CITY OF ALBUQUERQUE

April 15, 2020

Re: Weems Office Bldg
106 Wellesley Drive SE
Traffic Circulation Layout
Architect's Stamp 03-24-2020 (K16-D090)

SITE PLAN/ROOF PLAN 1" = 10'-0"

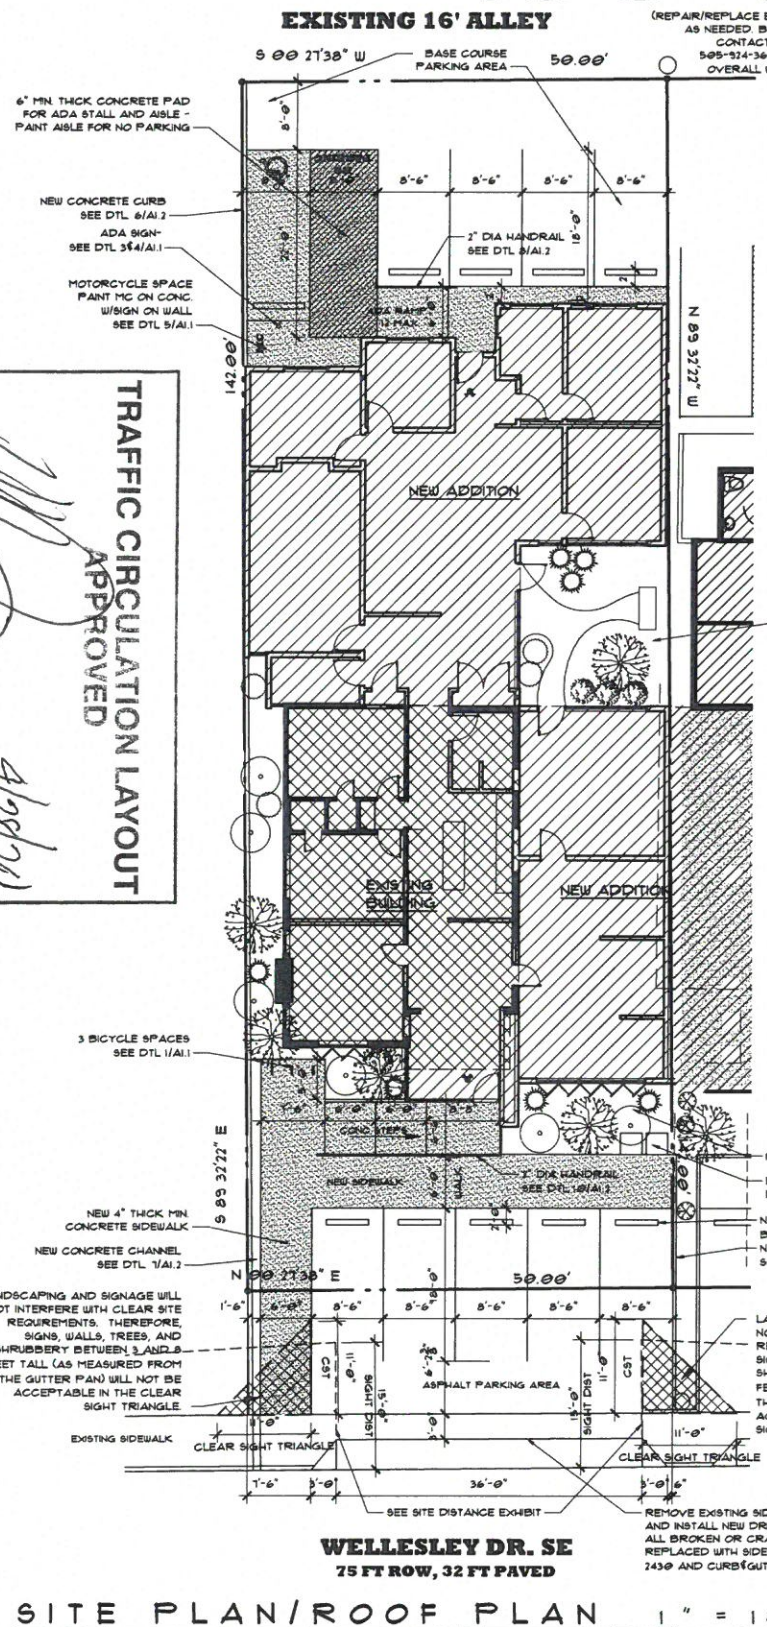
2. Identify the right of way width, and street widths on Wellesley Drive SE.
3. Per the IDO, a 6 ft. wide ADA accessible pedestrian pathway is required from the public sidewalk to the building entrances. Please clearly show this pathway and provide details.

5. A detail needs to be provided for landscape curbing.
6. Parking areas shall have barriers to prevent vehicles from extending over public sidewalk, public right-of-way, or abutting lots.

7. Provide a copy of refuse approval for any proposed refuse disposal/ container since no explanation has been given as to the disposal function.
8. It is not apparent what type of pavement surface is being proposed for parking area fronting Wellesley Drive. A hard driving surface will be required as part of this proposed project for parking area.

9. What type of surface is on the existing 16 ft alley? And what condition is the existing surface? If the surface needs replace, it is the responsibility of land owner to repair and/or replace.

9 RAMP DETAIL
 Al.2 1/2" = 1'-0"

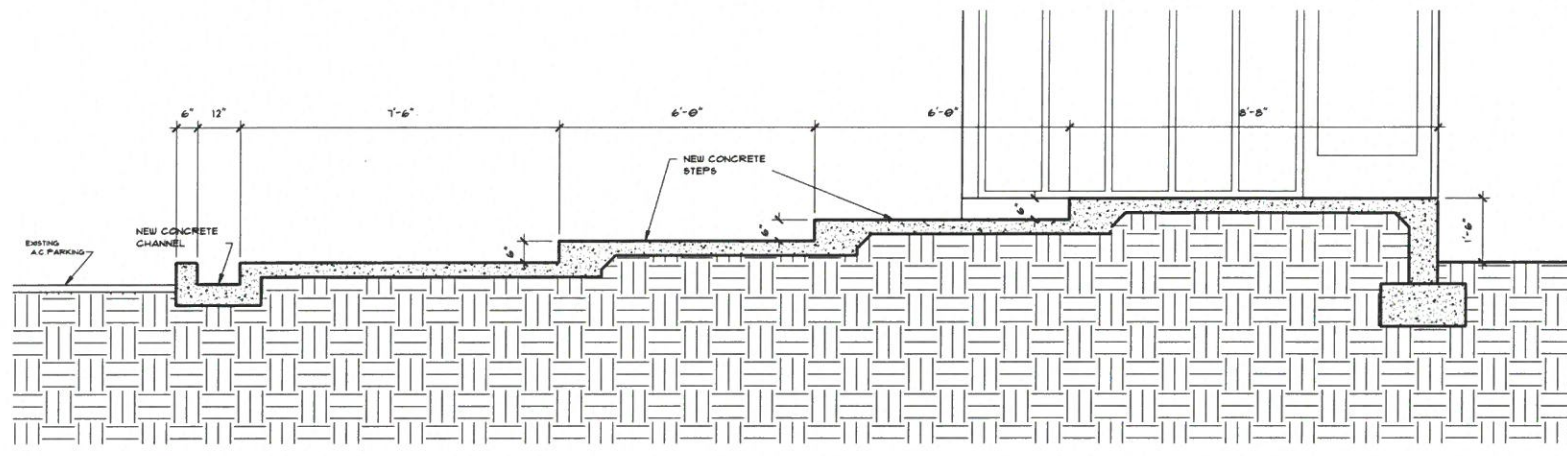
4. Per DPM, a 6 ft. wide ADA accessible pedestrian pathway is required from the ADA parking stall access aisles to the building entrances. Please clearly show this pathway and provide details for ramp (label ADA ramp slope 12:1 max.).

SITE DISTANCE EXHIBIT 1" = 100' - 0"

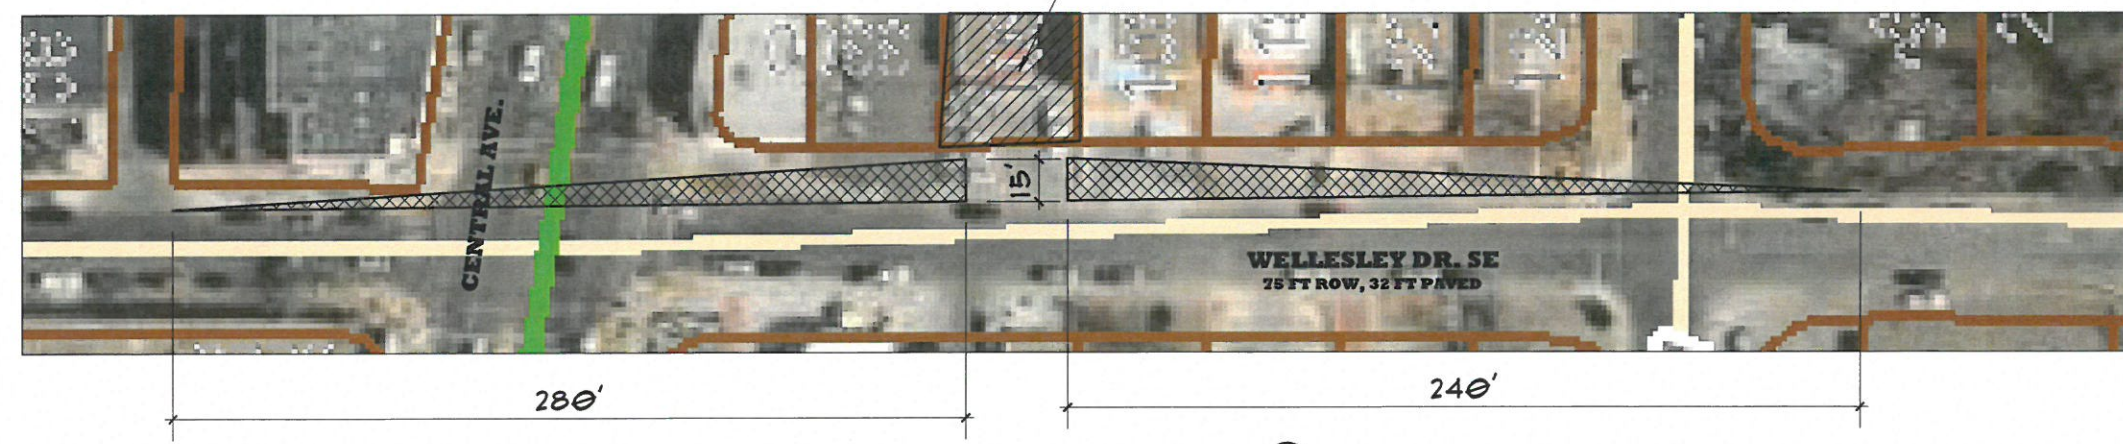
10. Please provide a sight distance exhibit..
